East Anglia One North (EA1N) and East Anglia Two  
(EA2) Offshore Wind Farms

Planning Inspectorate Reference: EA1N – EN010077 &  
EA2 – EN010078

Deadline 4 - 13 January 2021

East Suffolk Council's Response to Additional  
Information Submitted by Applicants at Deadline 3

| | Rev | Date | By | Comment | Approved: | AH | | | APFP Ref: 5(2) (o) | | Doc ref: 2.10 |

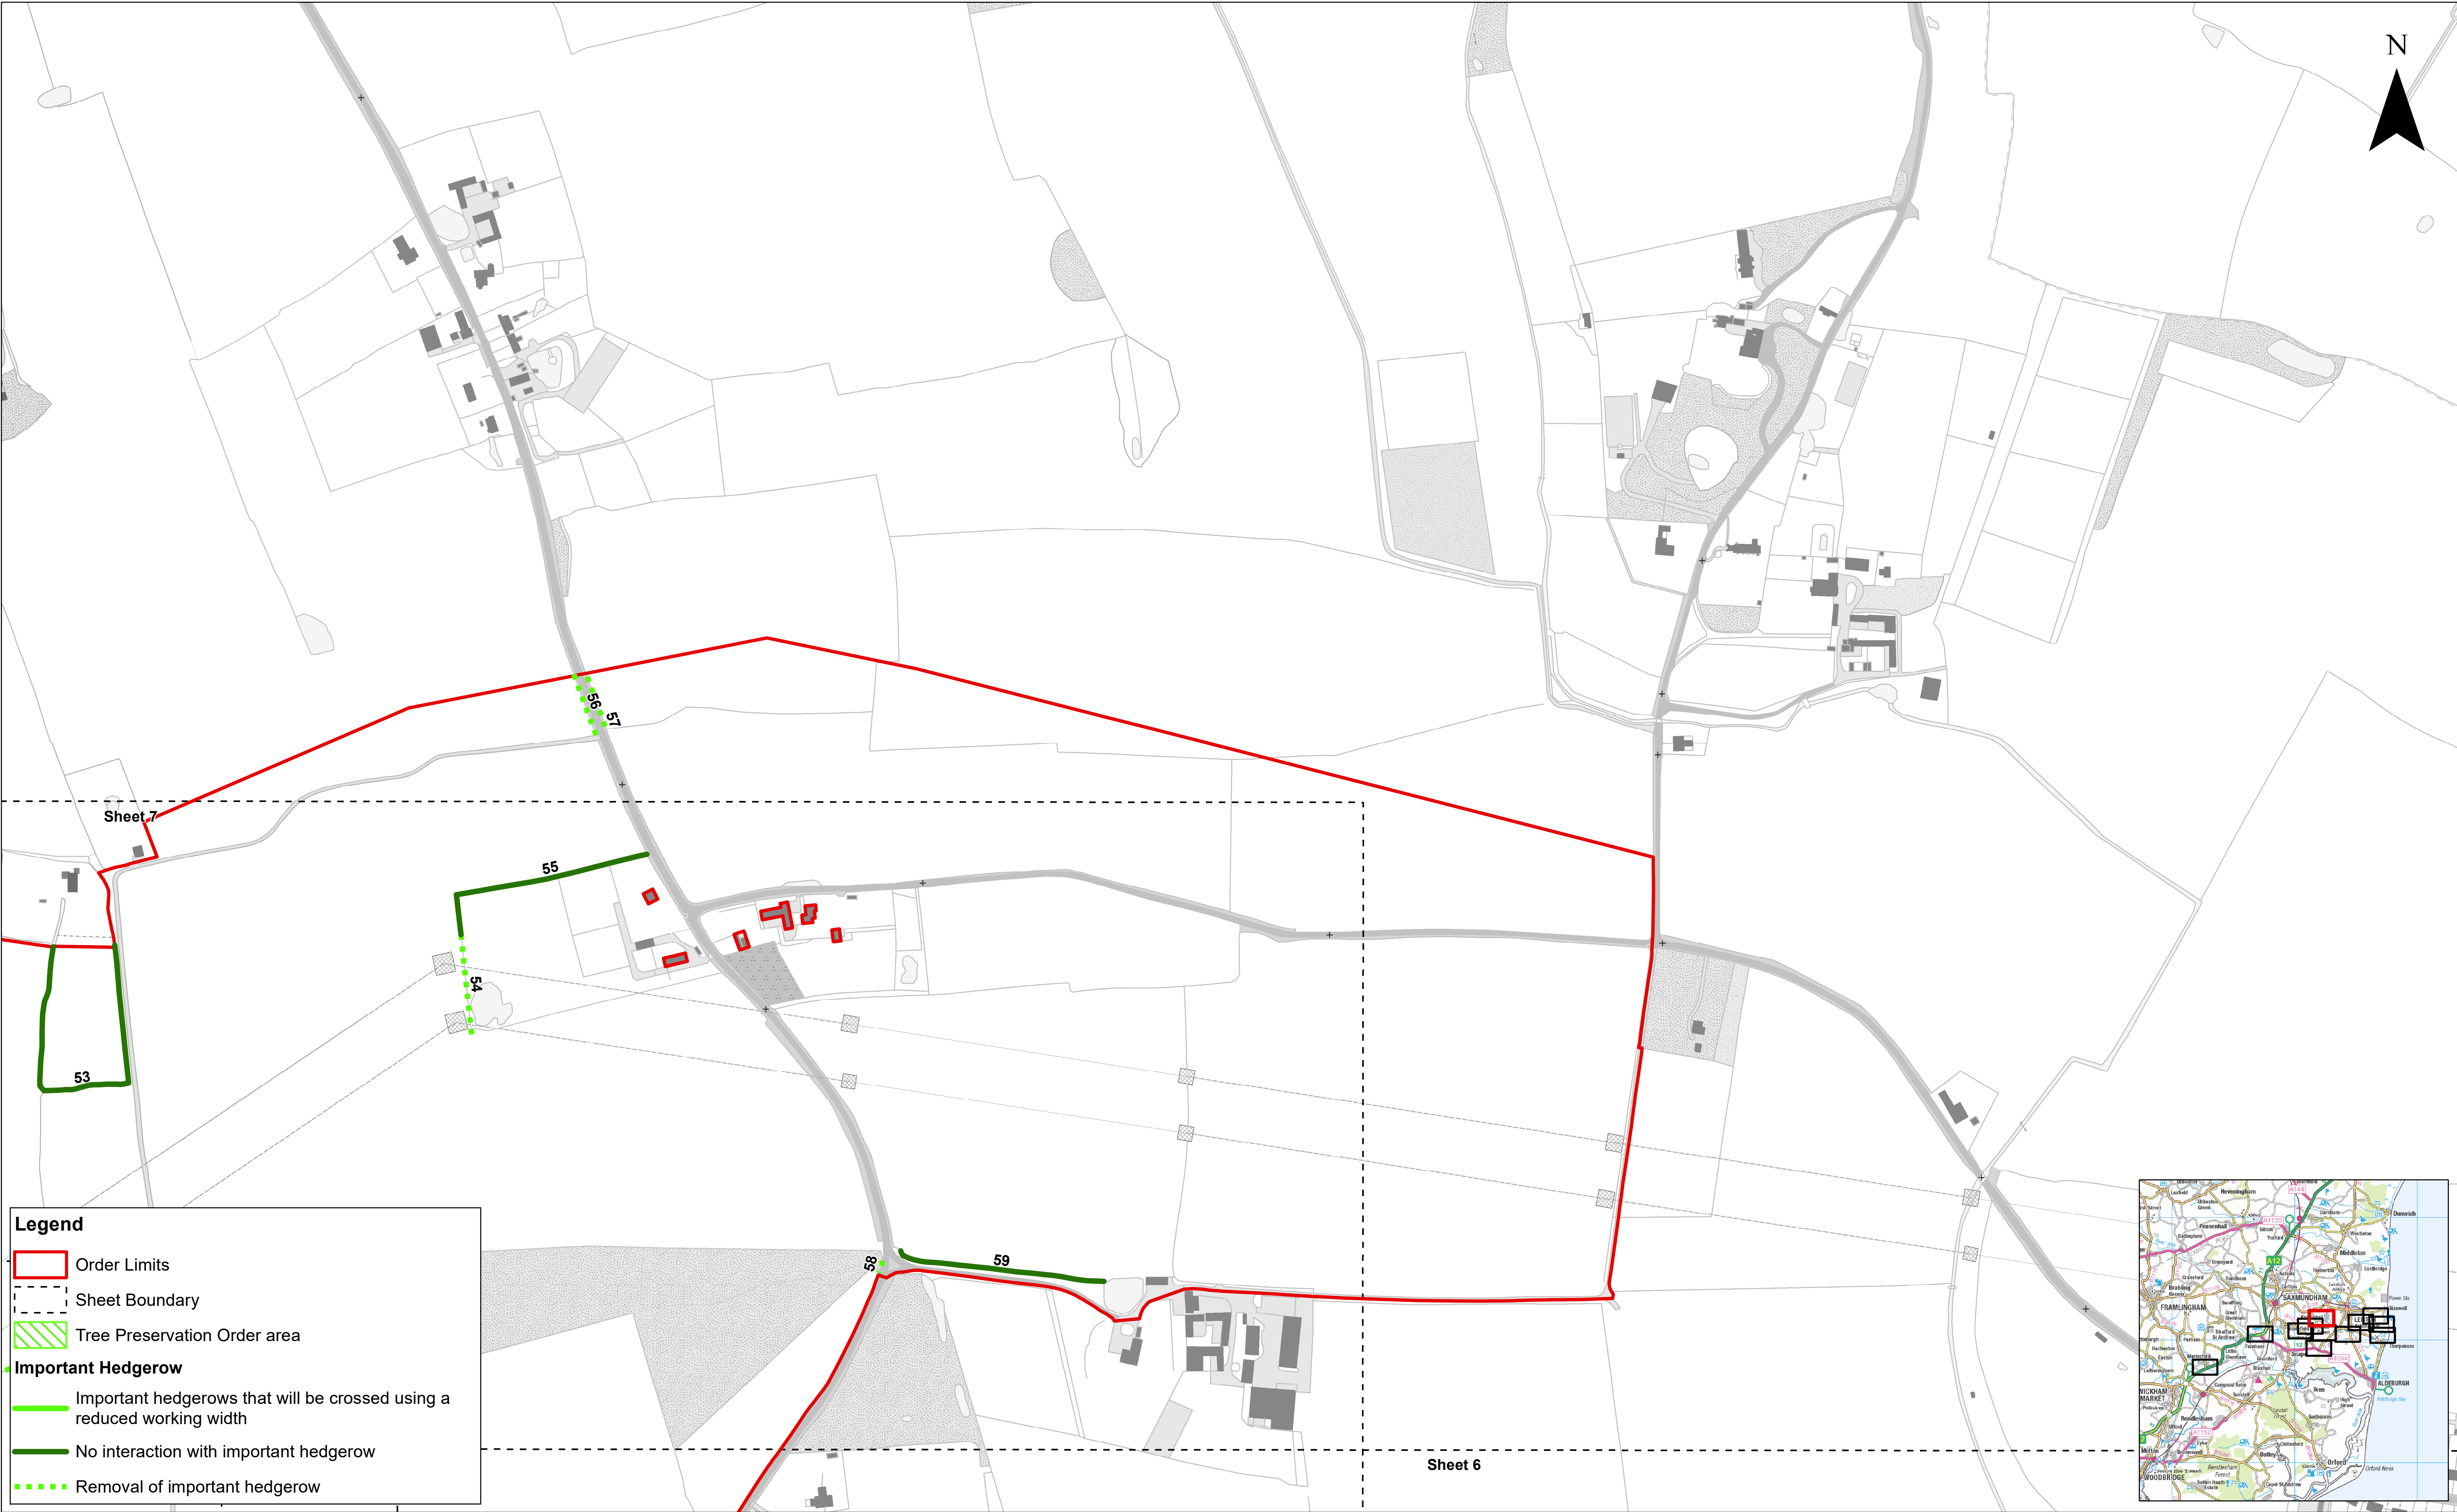
<b>Important Hedgerows and Tree Preservation Order Plan (REP3-010)</b>		
		Hedgerows 1 and 2 are identified within the Important Hedgerows and Tree Preservation Order Plan as being crossed with a reduced width but are identified within Schedule 11 as being removed. Clarification on this is required.
<b>Draft Development Consent Orders (dDCOs) (EA1N and EA2 – REP3-011)</b>

Figure: 8g
CHVP3: PROW between Moor Farm and Little Moor Farm

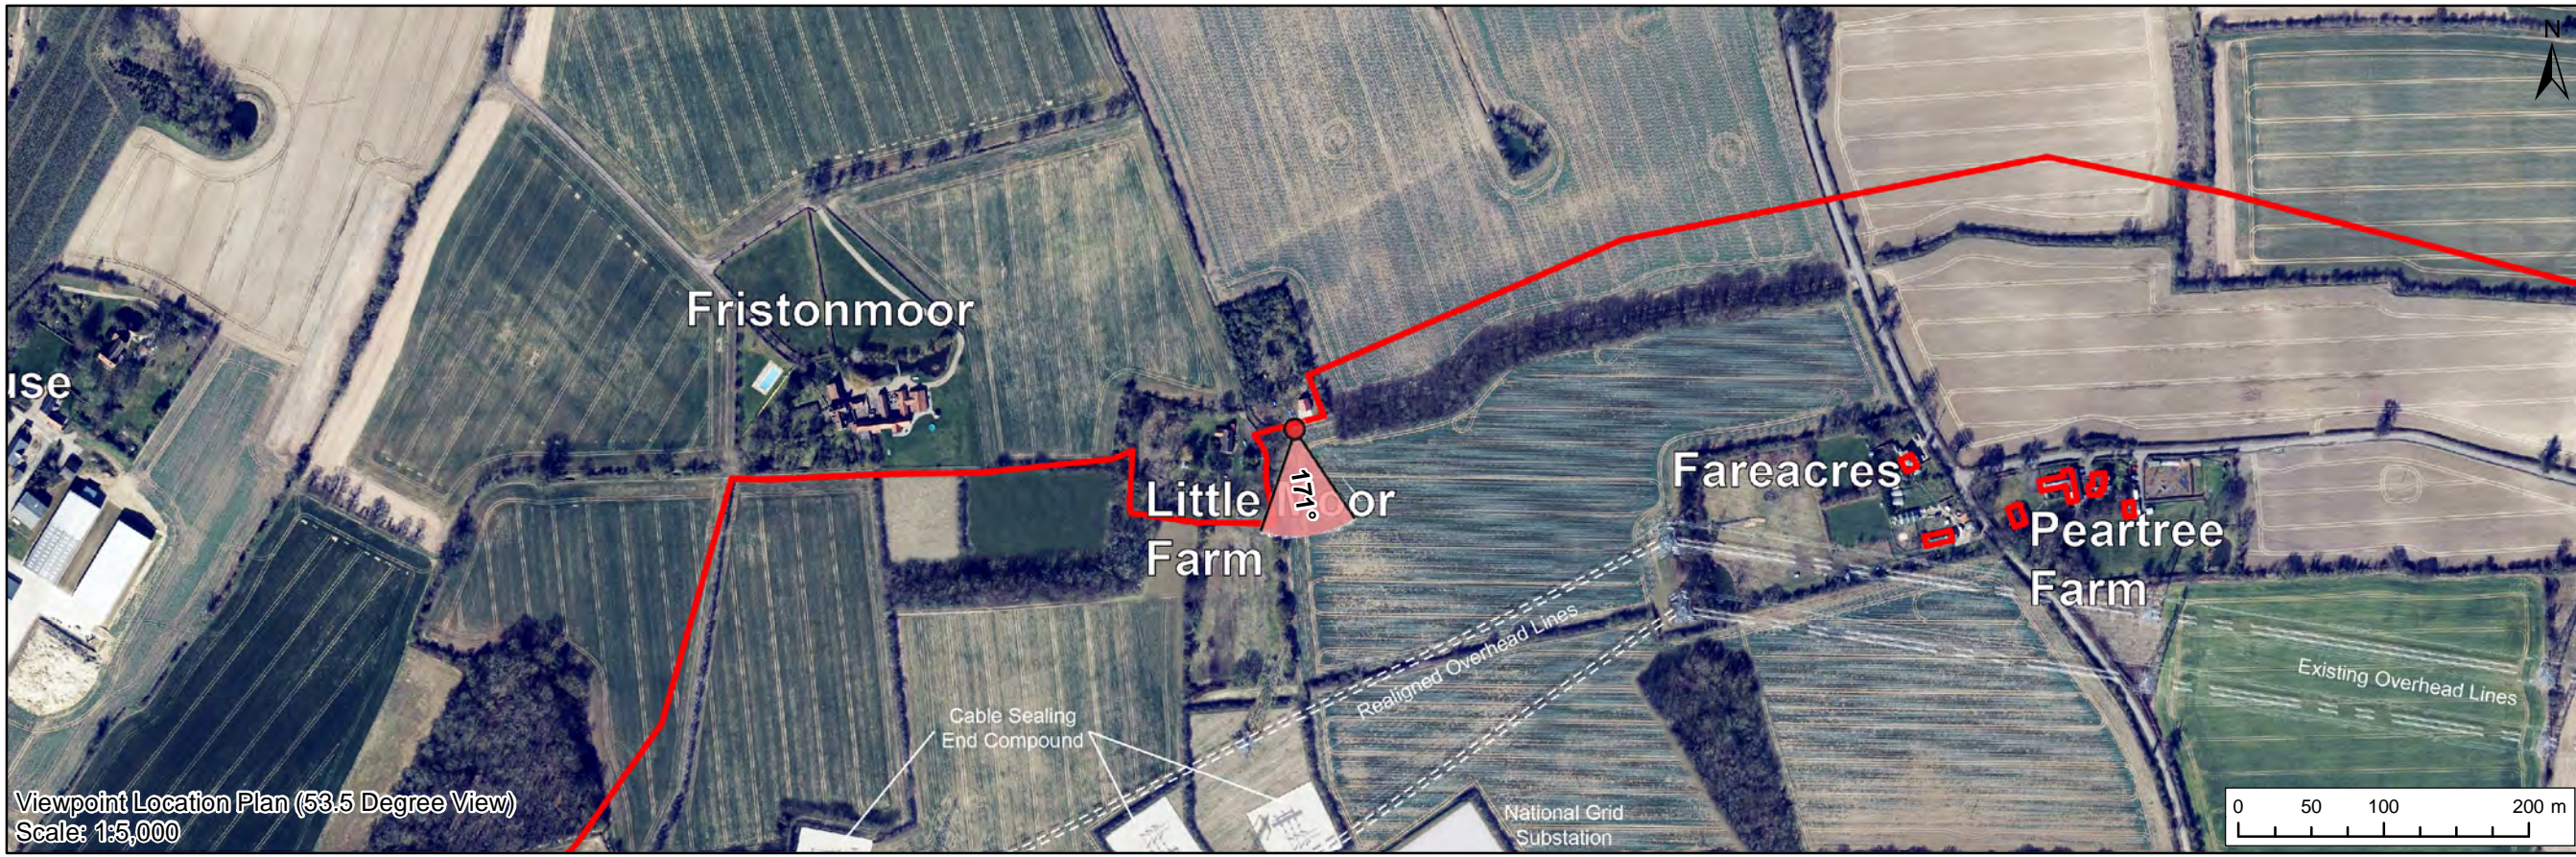
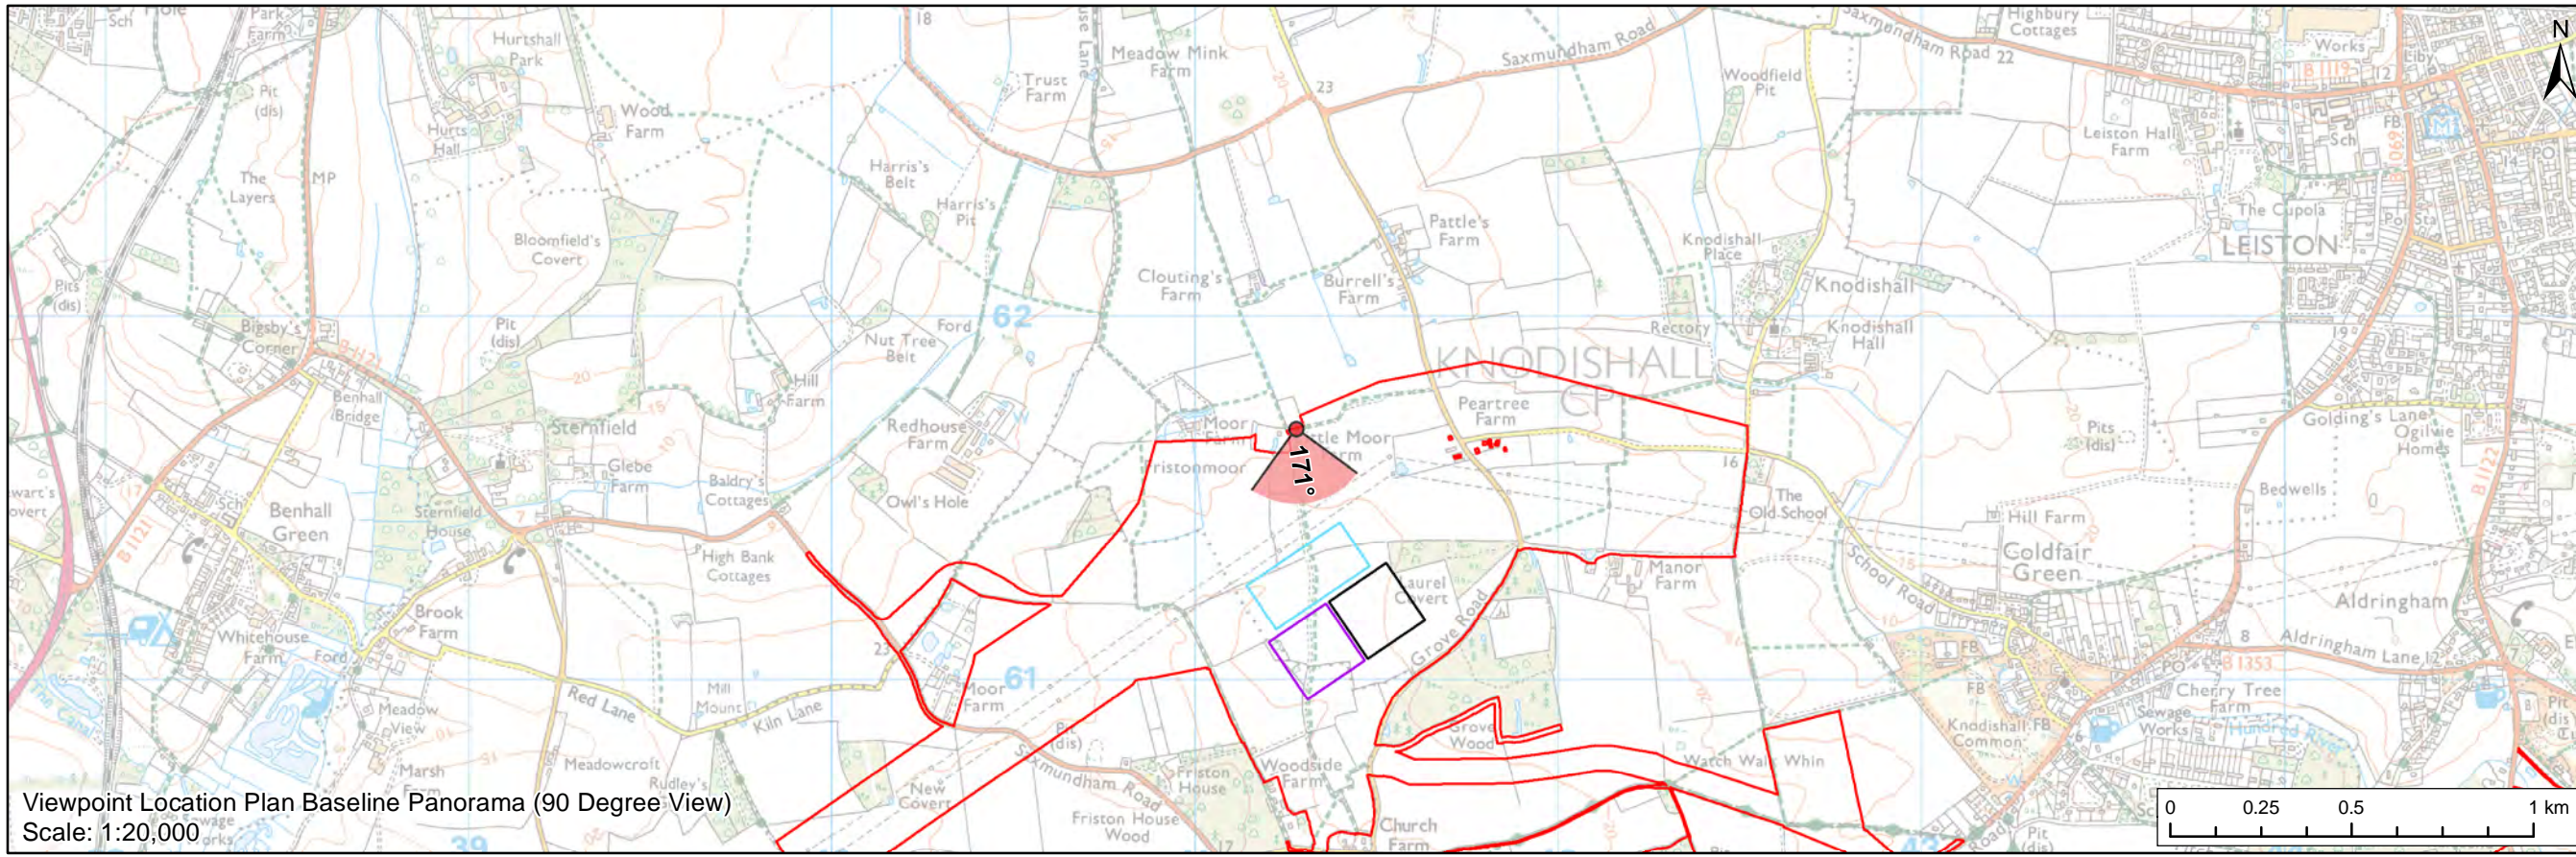
Both the reduction in scale of the infrastructure and the changes this allows to the locations of the substations are notable in Viewpoint 1. This viewpoint is most relevant in landscape terms, as it does not form part of a significant heritage viewpoint. As a part of the setting of Woodside Farm, however, it appears that the proposed landscape mitigation would have a similar visual impact as before the revisions.
